CITY OF ALBUQUERQUE

**Re: Mixed-Use Development: Del's Hide-A-Way Park, 4322 4th St. NW,
Traffic Circulation Layout, Engineer's Stamp dated 10-21-13 (G14-D071)**

TRAFFIC CIRCULATION LAYOUT

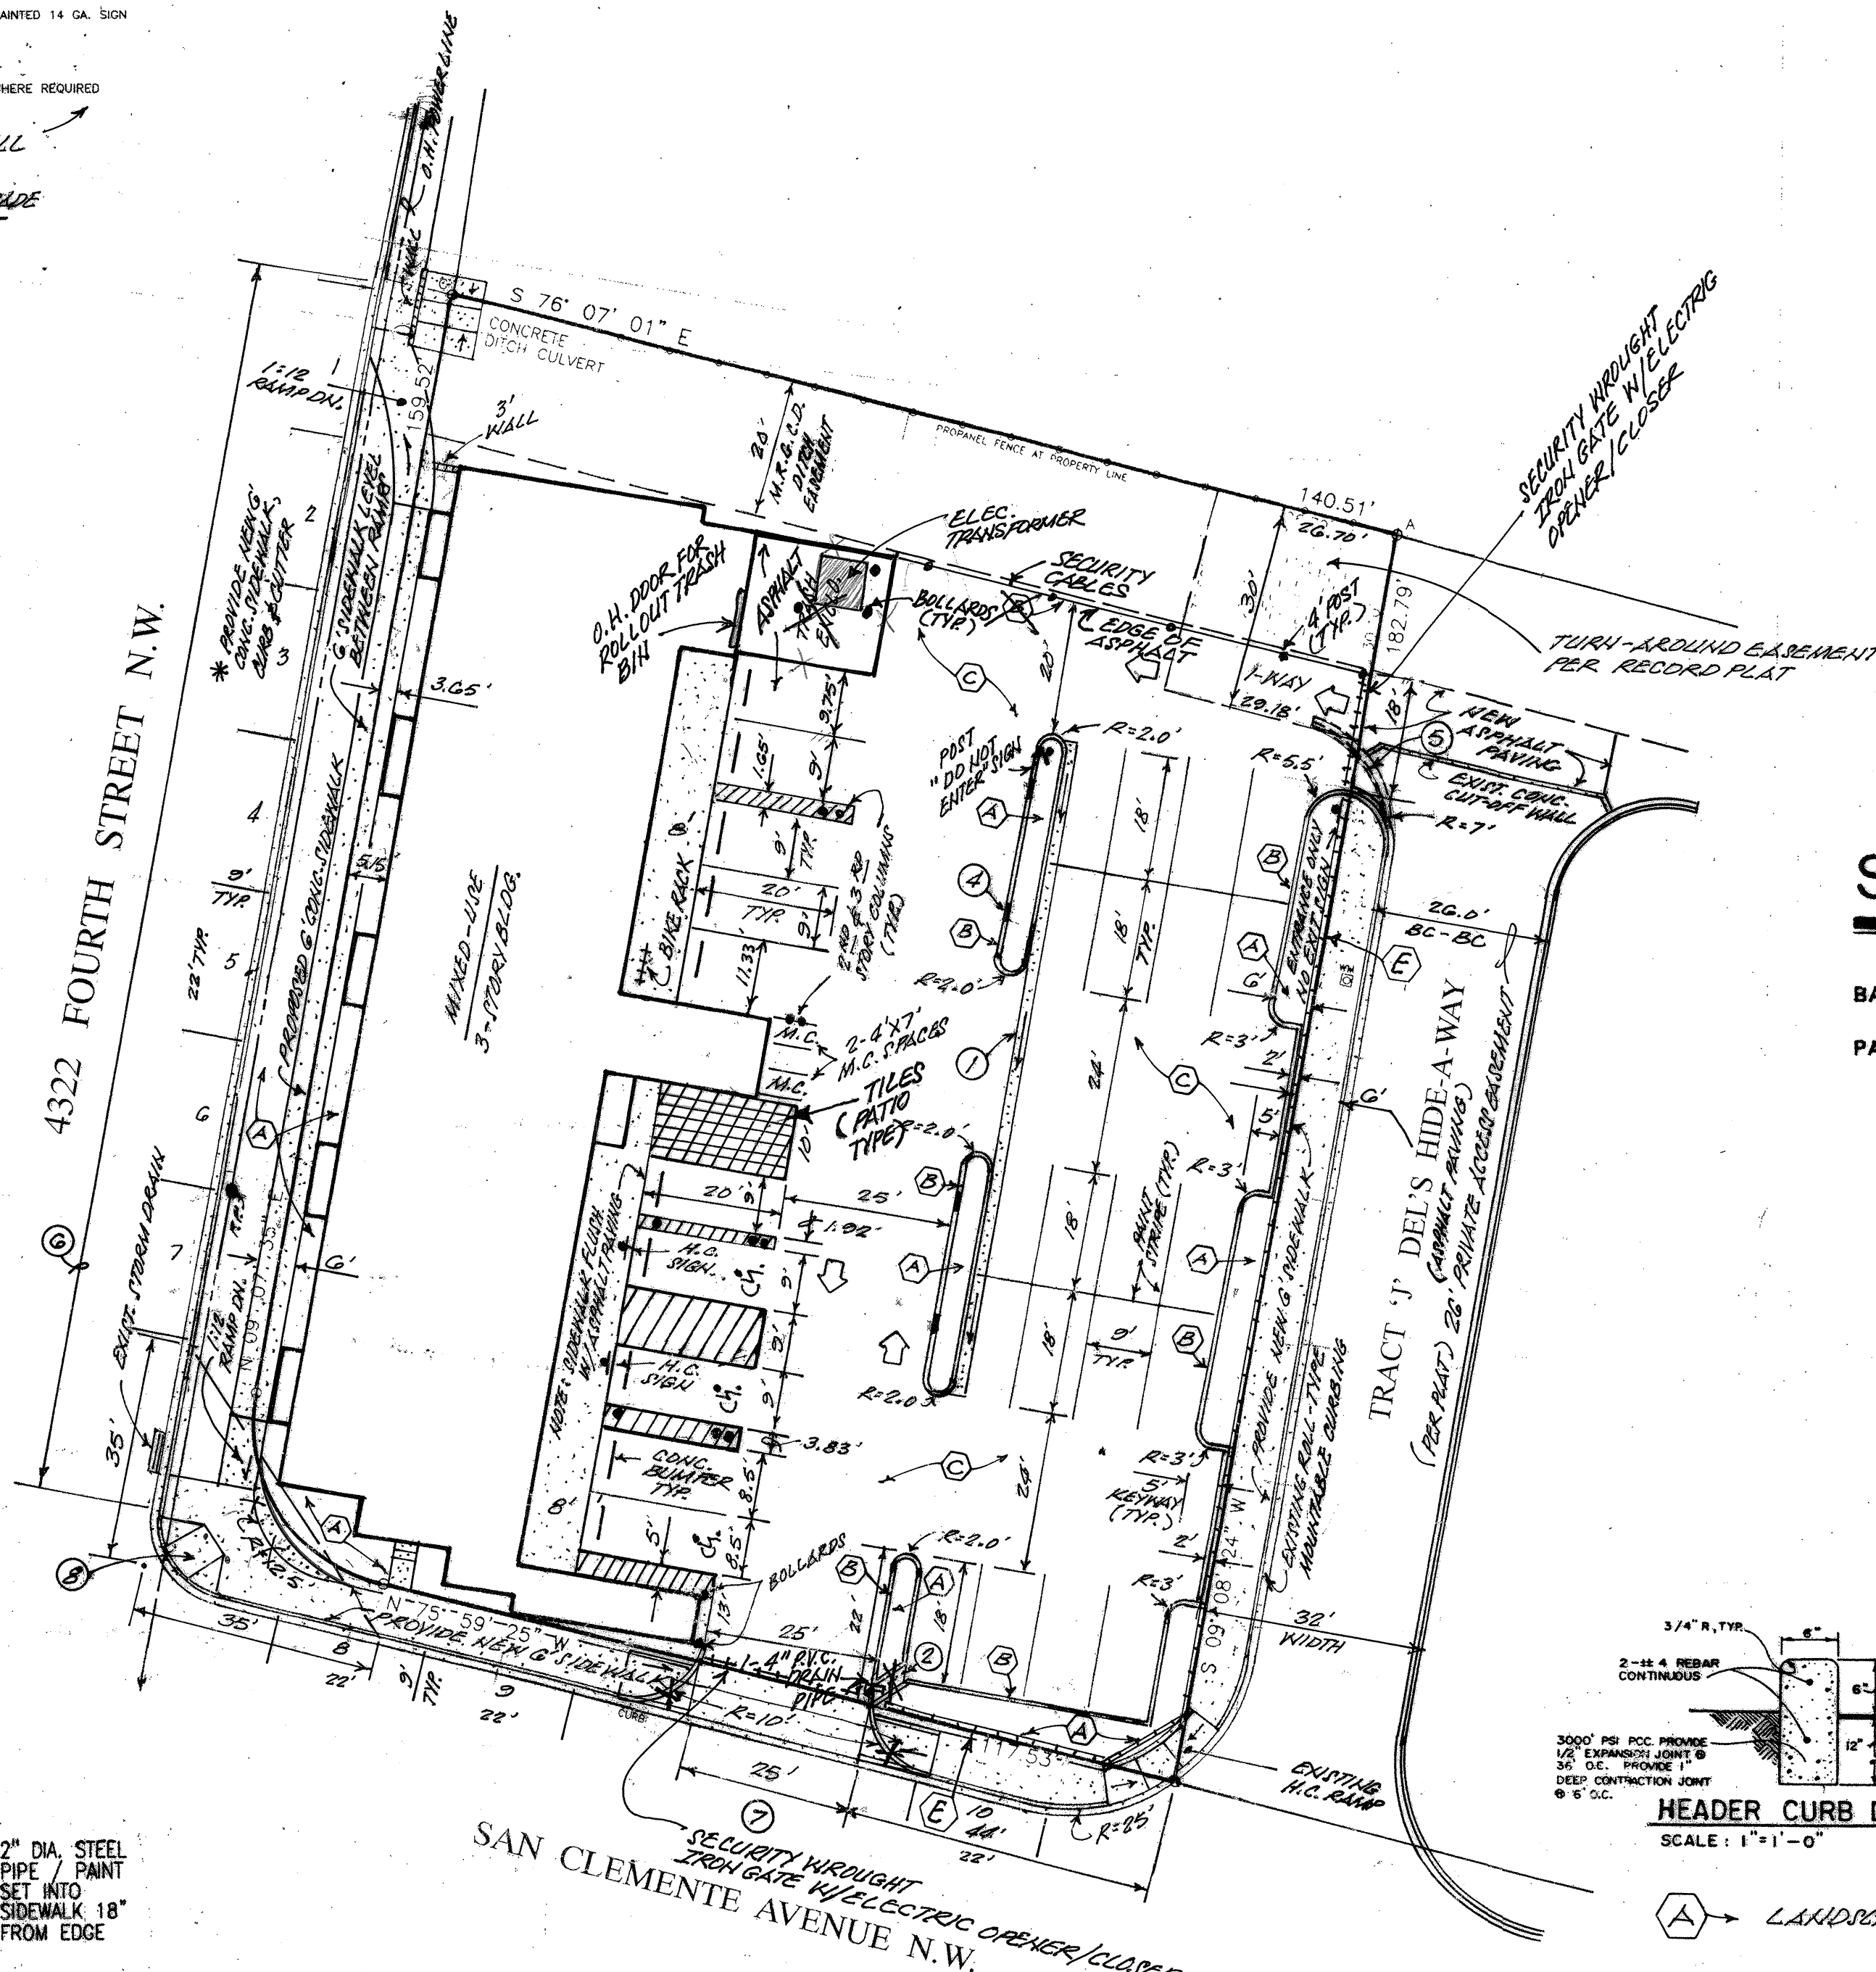
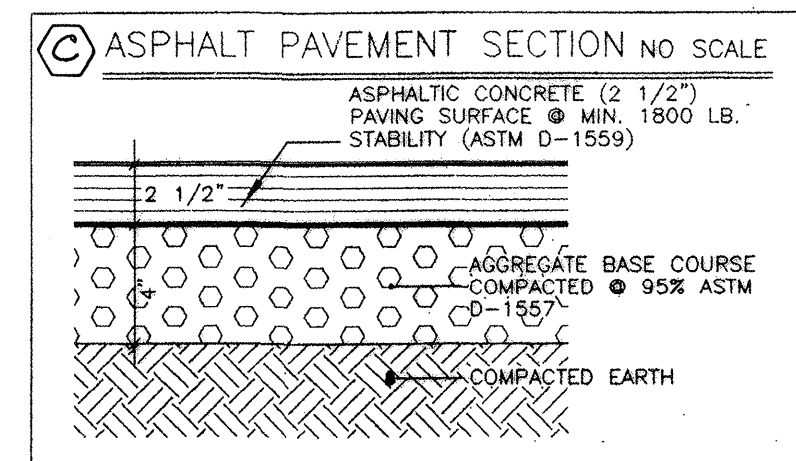
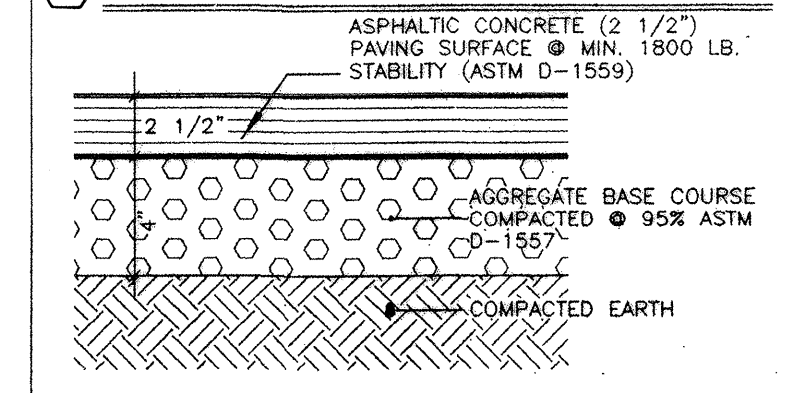
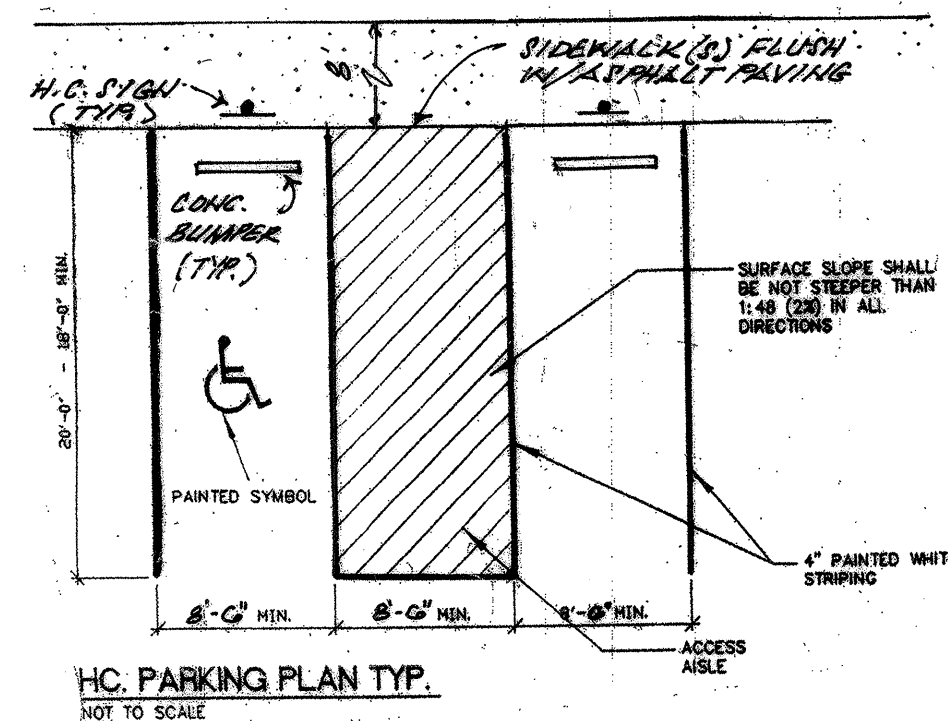
1. On-Street parking Allowance to fulfill zoning's parking requirement must be requested and approved by the Traffic Engineer, Kristal Metro prior to TCL approval. The application requires 15 working days. On-street parking allowances are based on available parking along public right-of-ways fronting the property. The business will only be granted 50% of available street parking.
2. The development of this site must be in compliance with current DPM and ADA standards and regulations.
3. Work within the public right of way requires a work order with DRC approved plans.
